Mountain View Electric Association, Inc. (MVEA) has these comments about the following:

Project Name: High Plains Filing #1, Final Plat

Project Number: SF 1824

FINAL PLAT
HIGH PLAINS FILING NO. 1
A PORTION OF THE SOUTHWEST QUARTER OF THE SOUTHEAST QUARTER OF SECTION 19, TOWNSHIP 11 SOUTH, RANGE 65 WEST OF THE 6TH P.M. COUNTY OF EL PASO, STATE OF COLORADO

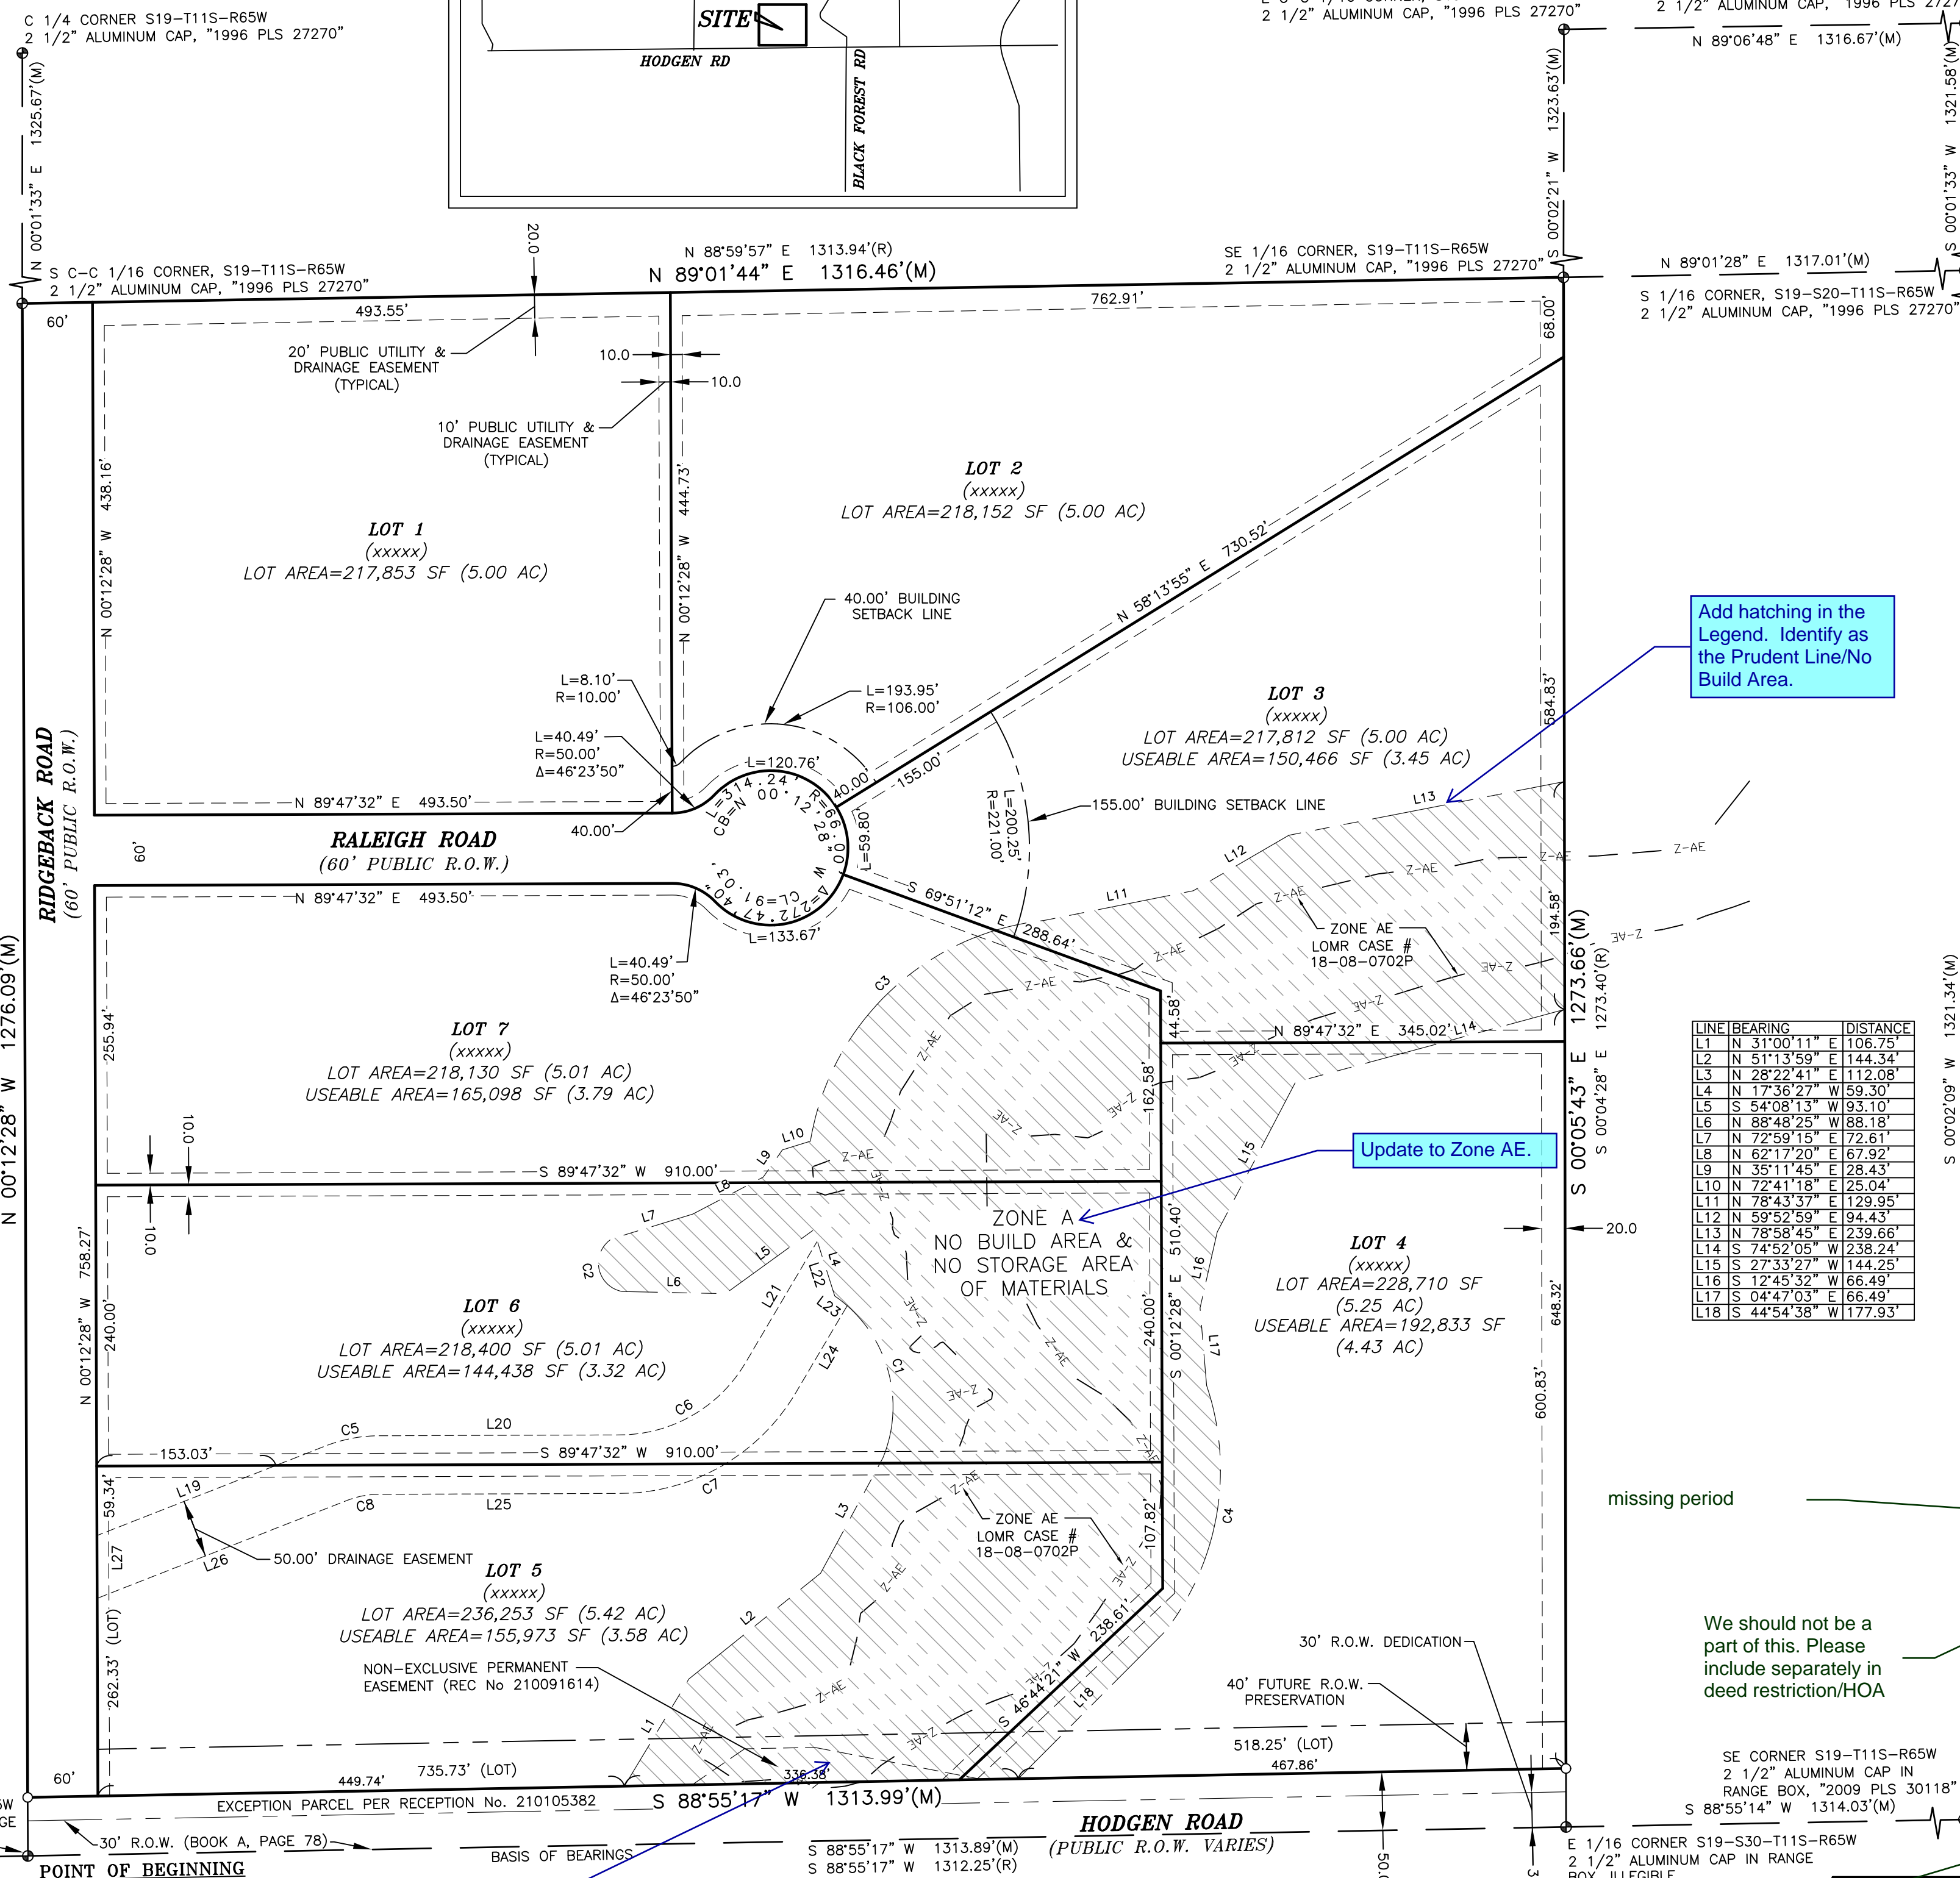
MVEA notes the ten (10) foot front, side and rear lot line utility easement along with a twenty (20) foot exterior easement on plat. MVEA also requests platting of existing MVEA facilities with easement on the plat. Additional easements may be required once a review of civil drawings with grading and erosion plan is provided to MVEA in order to serve this development.
